TfNSW reference: WST11/00046/25

SSD-24319456: BURTHONG ROAD NYMAGEE - FEDERATION GOLD PROJECT

Attachment 1

Figure 7: Hermidale-Nymagee Road upgrade extent

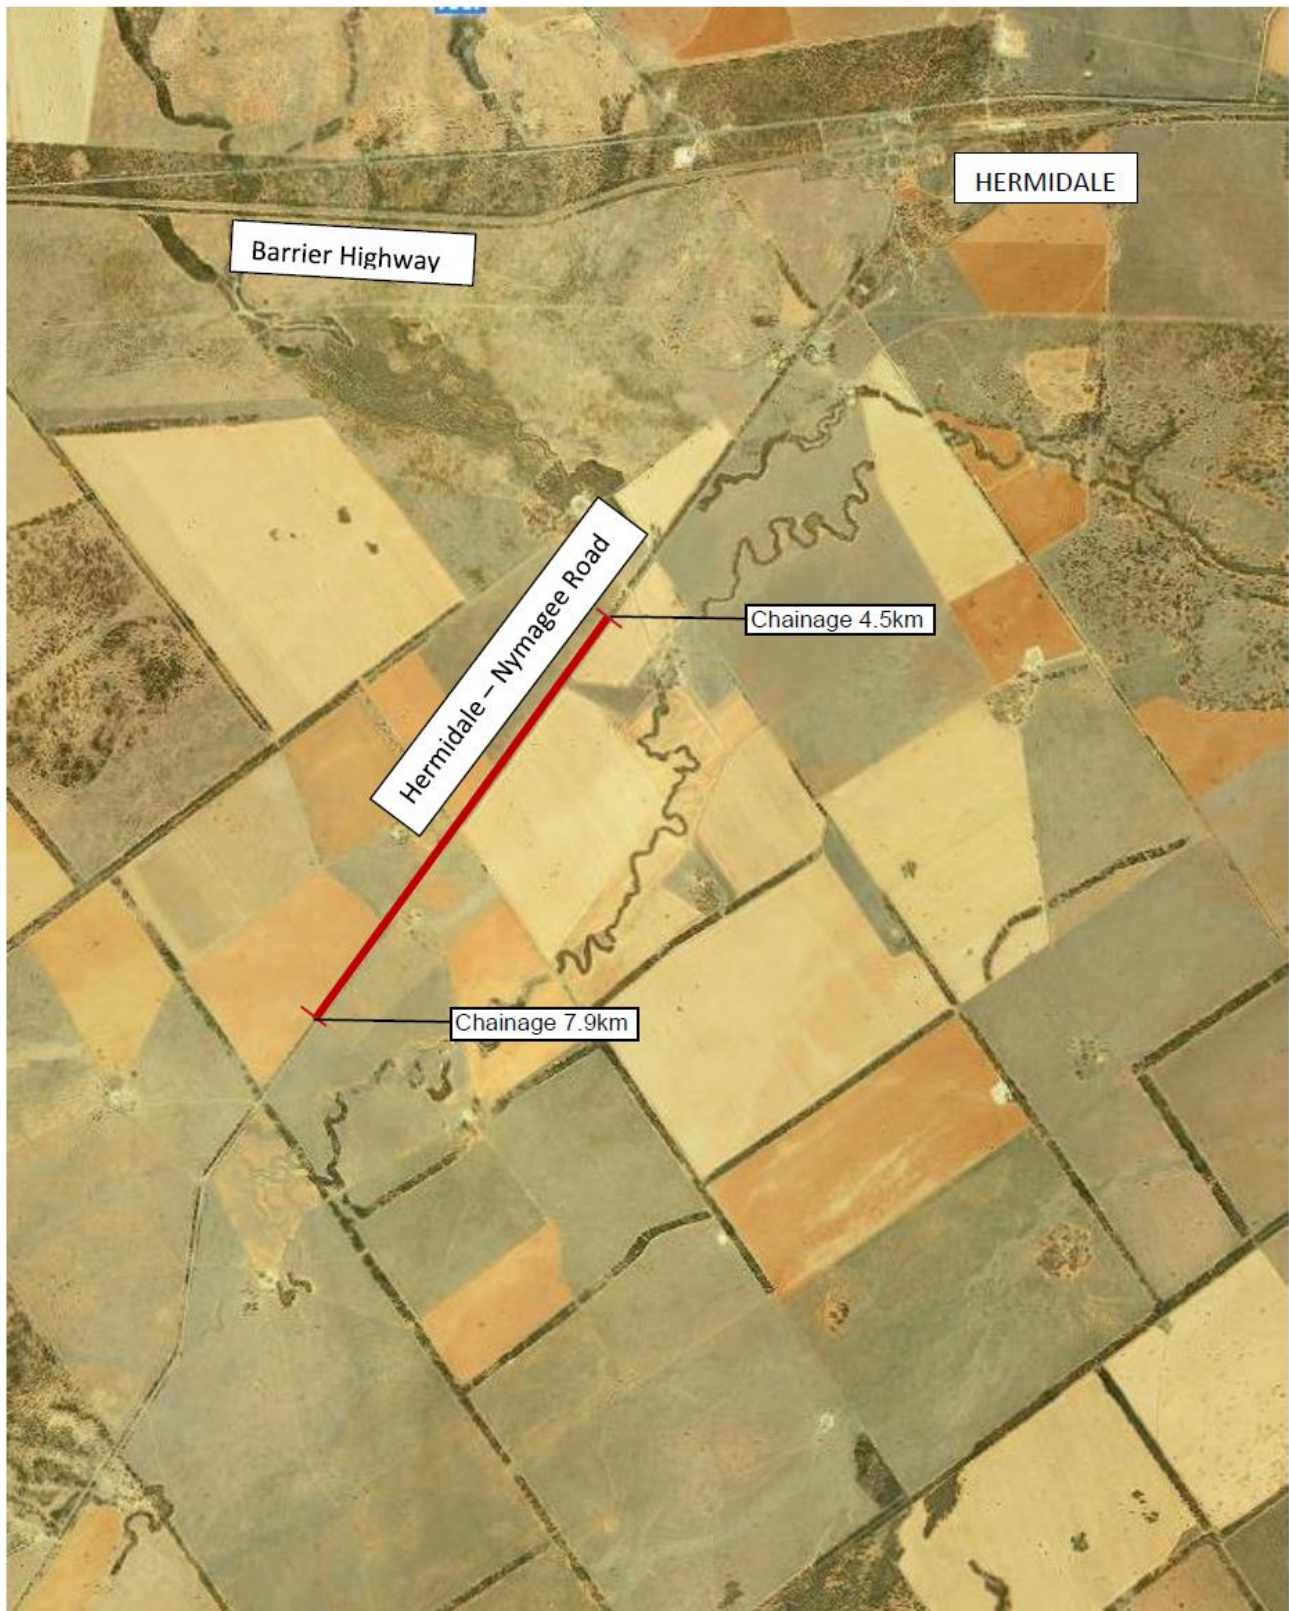
- With the Barrier Highway (HW08) continuing to be used for this development, an upgrade of the Rail Siding Access and Hermidale Nymagee Road intersections is recommended. Although identified in the submitted RTS information that BAR type intersections are required, given the types of haulage vehicles and their slow operating speeds in what is otherwise a high-speed environment, TfNSW recommends higher order treatment to cater for movements safely and efficiently. This would involve a CHR type intersections, with an AUL at Hermidale Nymagee Road.
